29 October 2020

Objection to Proposed waste collection, treatment and disposal Facility (SSD 10396) at 23-43 and 45 Tattersall Road, Kings Park NSW 2148

- 1.1 We act for Autorecyclers Pty Ltd (**AR**) and make this submission on their behalf objecting to the State Significant Development (**SSD**) Application lodged by Sell and Parker Pty Ltd (**Proponent**) for the expansion of throughput of an existing resource recovery facility from 350,000 to 600,000 tonnes per annum (**tpa**) of scrap metal (**SSD 10396**) (**the Proposal**) at the 'Sell & Parker' site, at 23-43 and 45 Tattersall Road, Kings Park (**Proposal Site**).

Figure 2 – Site, noise monitoring and receiver locations

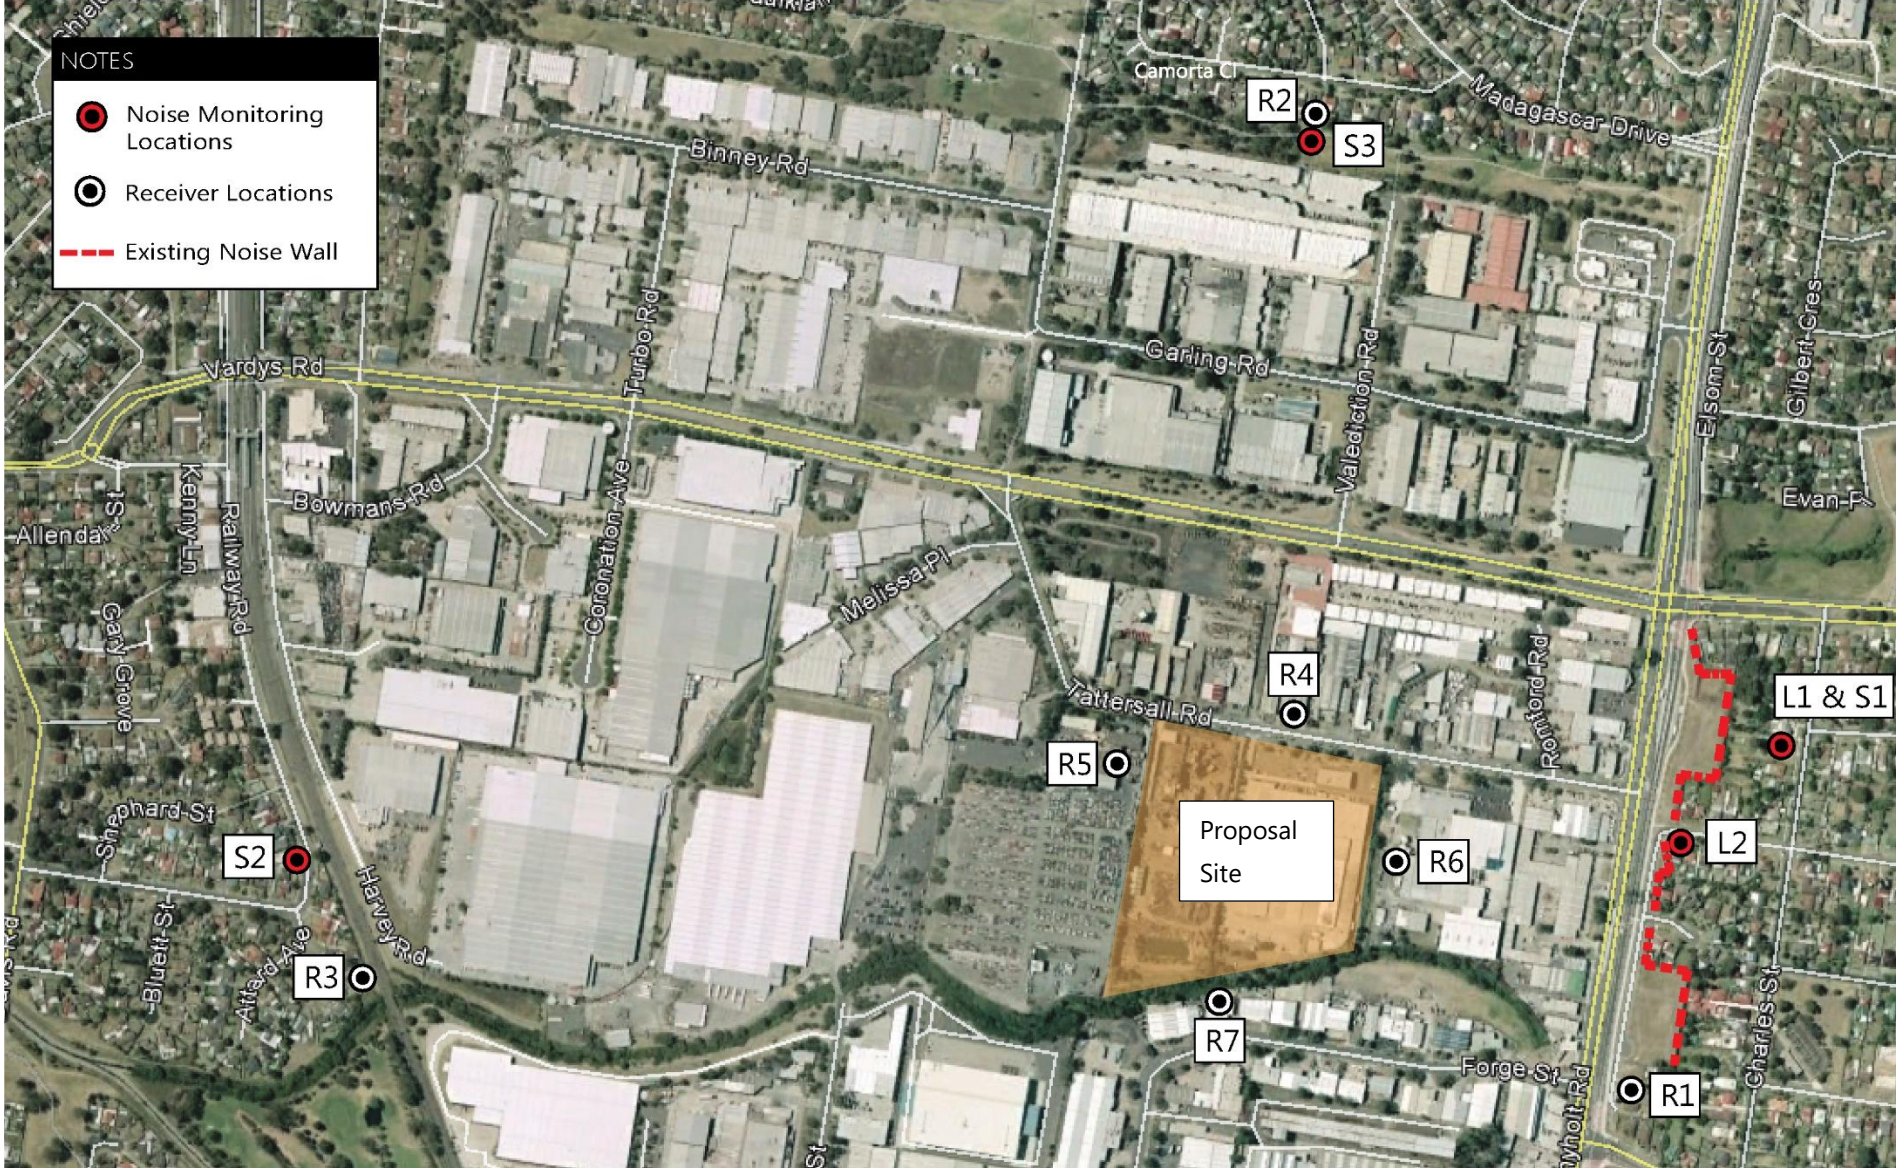
As detailed in the Day Design Review, the NIA does not provide adequate short-term noise data to the west of the Proposal Site as data was only obtained from only one noise monitoring location receiver (S2). Long-term noise data recorded from the west of the Proposal Site has also not been obtained. From this, concerns are raised over the Proponent's method for determining the existing background noise levels as Receiver 3.

The EPA has acknowledged, during the assessment of nearby developments, that the area surrounding Receiver R3 should have an amenity category of 'Suburban'. Based on this, the Day Design Review B suggests that the data gathered at Receiver R3 is incorrect and should be re-analysed with the correct categorisation in this location.

5.1.1 Observation

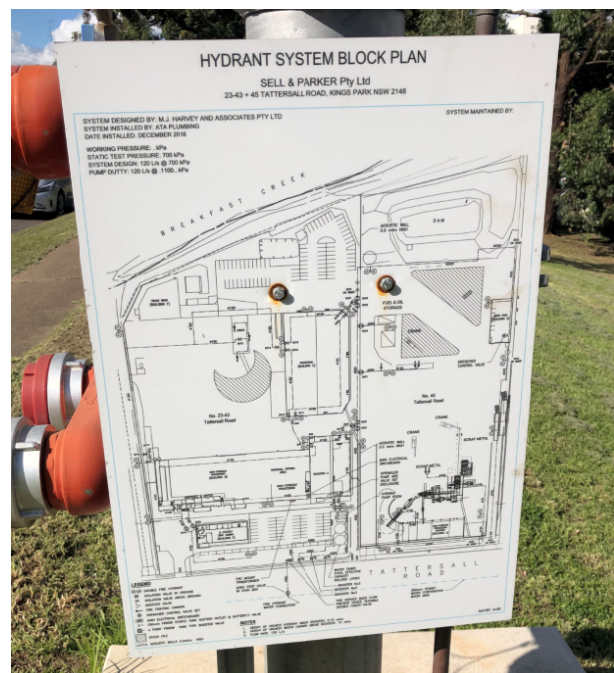
1. The existing booster valves are not secure or locked in the open position.
2. The existing booster inlet pipes do not have an isolation valve downstream of the booster inlets. Booster inlet pipes are required to have an isolation valve if the head of the inlets can be greater than 50kPa due to the pumps running.
